**RE: Application by Rampion Extension Development Limited for an Order Granting Development Consent for the Rampion 2 Offshore Windfarm Project**

### **Horsham District Council Deadline 4 Submission**

## **EN010117: Application by Rampion Extension Limited for the Rampion 2 Offshore Wind Farm**

HDC Response to the Applicant's additional information/submissions received Deadline 3.

Company:	WSP	Rampion 2 Offshore Wind Farm
Drawn By:	BRYCC	Figure 18.12f
Chk/Aprvd:	RYLOR	Oakendene Onshore Substation
Drawn Date:	31/07/2023	Viewpoint SA3b: PRoW 1786, Taintfield Wood (Existing View)
Status:	FINAL	Environmental Statement

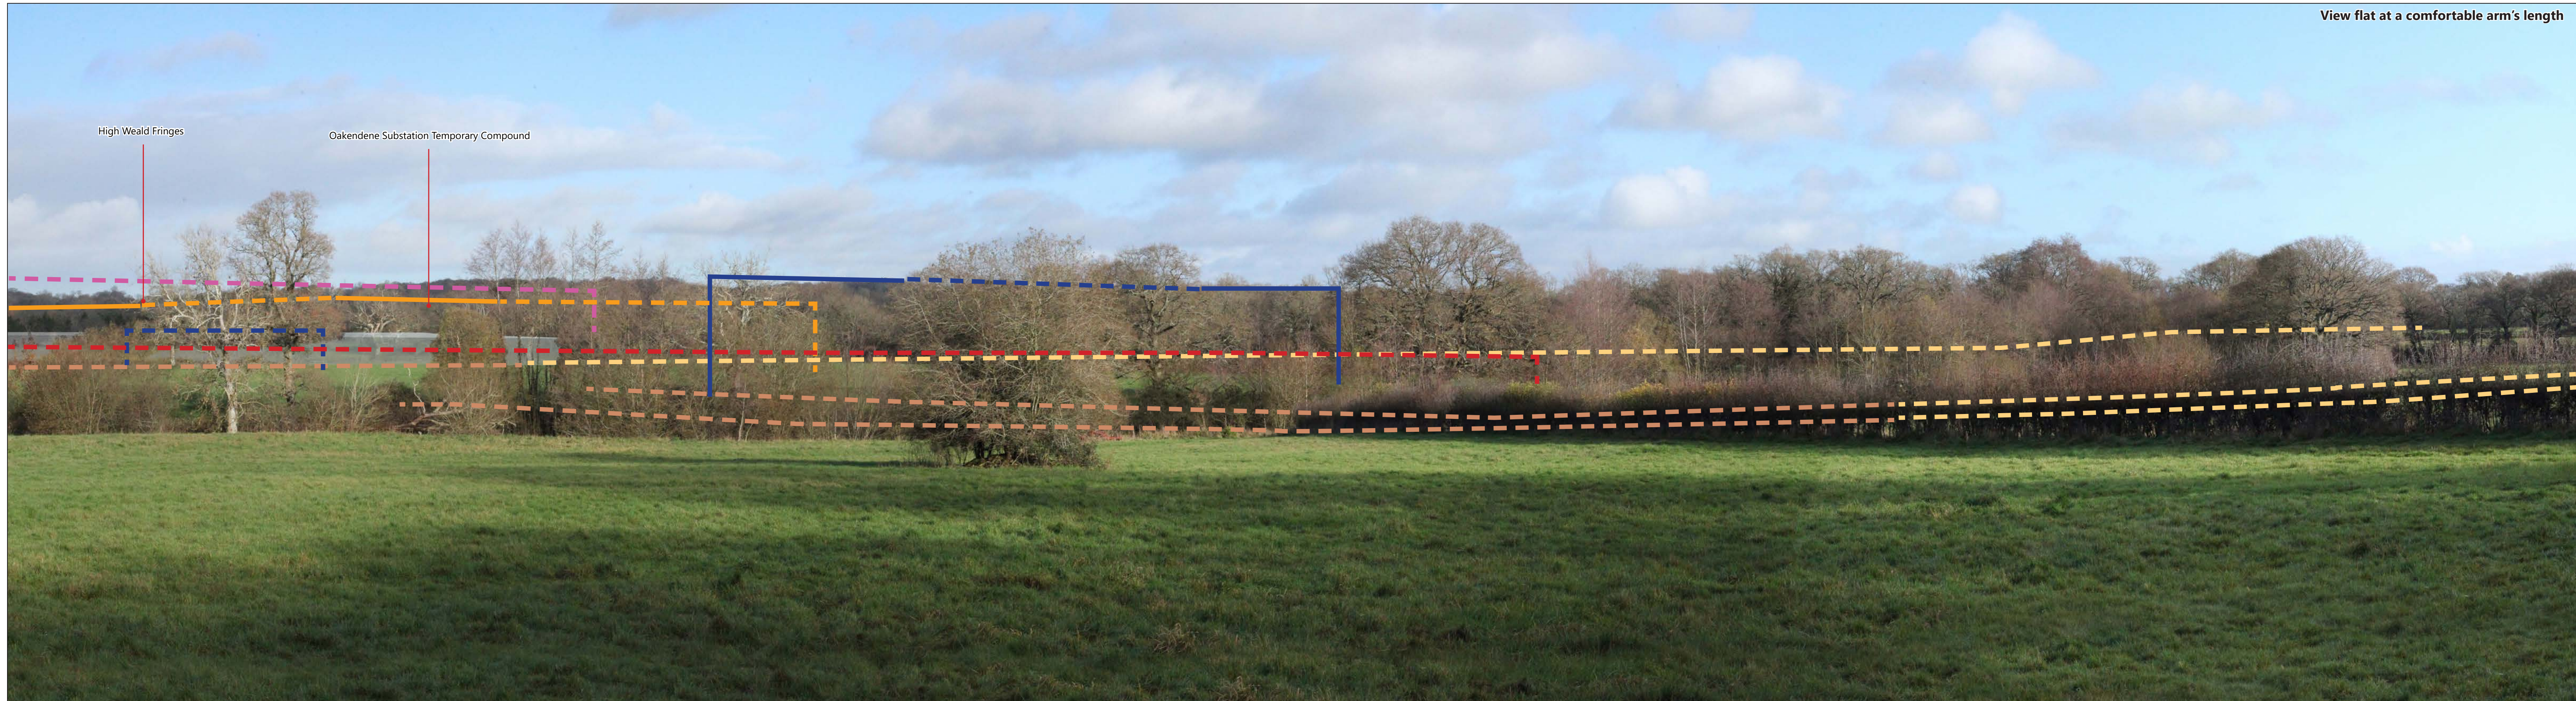
|  | <i>14. PRoW 1786 between east of Taintfield Wood and A272 is identified as having a residual Significant effect which is agreed with. HDC therefore queries the absence of a more robust buffer planting between the public right of way and the site's southern boundary? Whilst this area is currently outside of the application's red line boundary, it seems unsatisfactory that significant effects are left unmitigated.</i>   | <i>Ref B14<br/>The provision of off-site planting to mitigate views from PRoW 1786 would require landowner consent and is also likely to block elevated views towards Oakendene Manor from PRoW 1786. Therefore, reference has been made to the architectural strategy whilst noting also that the substation footprint is based on maximum parameters.<br/>The Outline Landscape and Ecology Management Plan [APP-232] includes a</i>   | HDC welcomes the amendment to the southern boundary treatment which now retains existing vegetation by providing a trenchless crossing (LV5).  |

|  | <p><i>Failing the feasibility of this, reducing the footprint of the substation to allow for a wider buffer to be planted within the confines of the red line must be explored.</i></p>    | <p><i>series of landscape design principles, other opportunities and an Architectural Strategy (consistent with the DAS) to provide further mitigation in addition to the Indicative Landscape Plan (ILP). The Outline Landscape and Ecology Management Plan [APP232] is being updated for submission at Deadline 3 with further details on mitigation measures regarding landscape design, ILP and an Architectural Strategy. Further detail will also be provided in the stage specific Landscape and Ecology Management Plans that would be delivered as part of the detailed design process to the relevant authority for agreement. The delivery of these documents is secured through Requirements 12 and 13 of the Draft Development Consent Order [PEPD-009] which has been updated at Deadline 2.</i></p> <p><i>Further detail would be provided in the stage specific Landscape and Ecology Management Plans that would be delivered as part of the detailed design process to the relevant authority for agreement. The delivery of these documents is secured through Requirements 12 and 13 of the Draft Development Consent Order [PEPD-009] (updated at Deadline 2).</i></p> <p><i>The Applicant will continue to engage with Horsham District Council on these points.</i></p> |  |
